memorandum

subject Review of 5637 East Mercer Way - Reasonable Use Exception and Variance Applications (CAO15-001 and VAR18-002)

On behalf of the City of Mercer Island (City), Environmental Science Associates (ESA) reviewed the application materials for the proposed development located at 5637 East Mercer Way, in the City of Mercer Island, Washington (King County Parcel #1924059312). This review is to determine if the proposed project complies with Mercer Island City Code (MICC) Chapter 19.07 (Environment) and Conditions of Approval outlined in the Hearing Examiner Decision following the most recent Remand Hearing.

<p>THE HEALEY ALLIANCE AZ 2505 N 25th DRIVE, GOODYEAR, AZ 85526 • (480) 444-6766 ARCHITECTS</p>	<p>Mi Treshouse, LLC, 5631 EAST MERCER WAY MERCER ISLAND, WA.</p>	<p>SITE PLAN DATE: 03/20/24 DRAWN BY: [Name] CHECKED BY: [Name] SCALE: 1" = 20'</p>
--	---	--	--

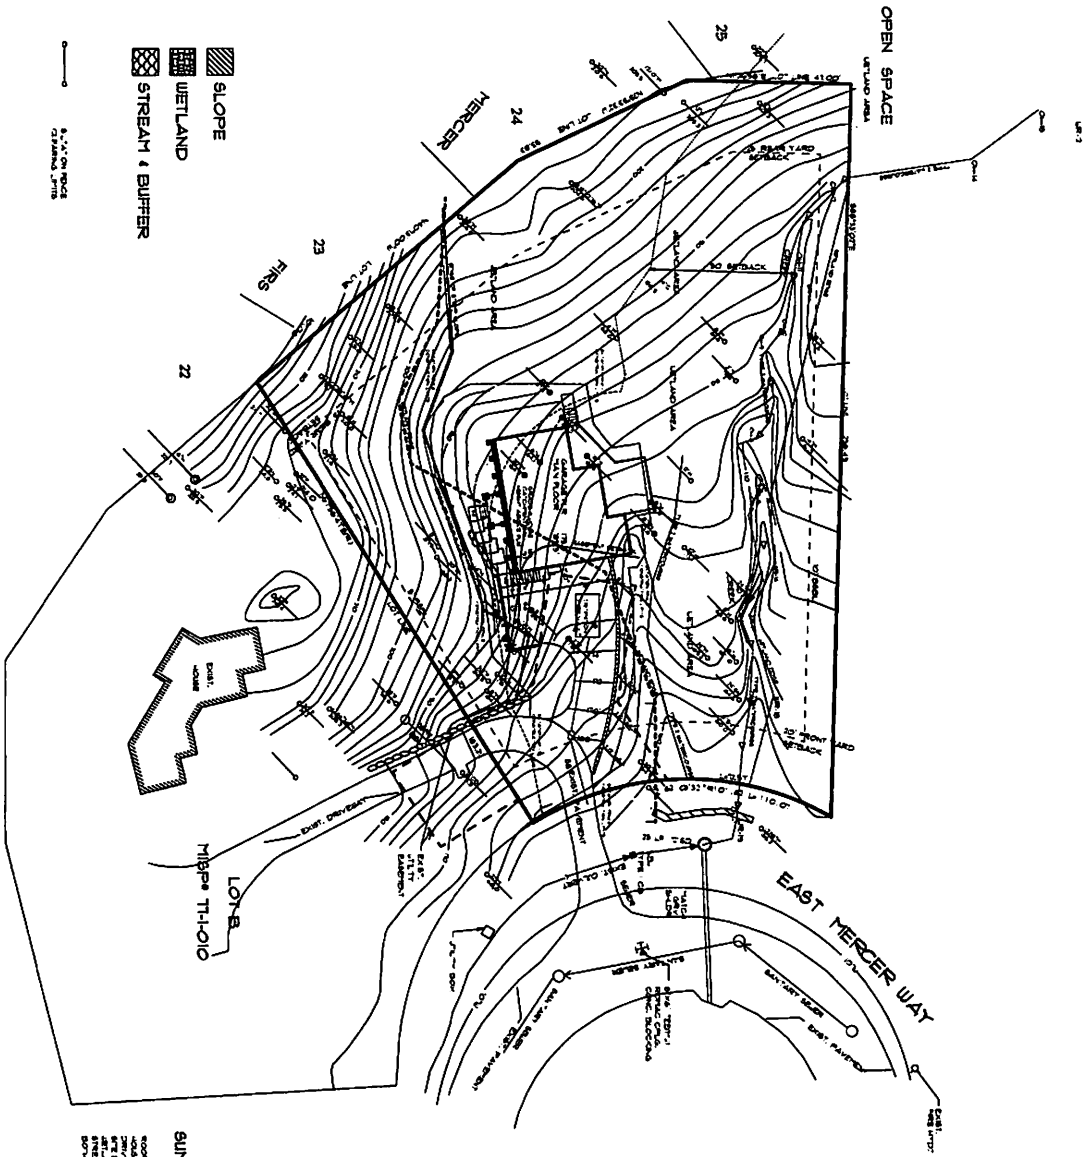
- b. Revise the *Revised Critical Areas* dated January 26, 2021 to correct the parcel number to 192405-9312 instead of 192405-0312.
2. The Site Plan does not show a split rail fence around the north, west, and south extent of the clearing limits. ESA recommends the Site Plan be updated to include the split rail fence as described in the Conditions of Approval determined by the Hearing Examiner December 15, 2021.
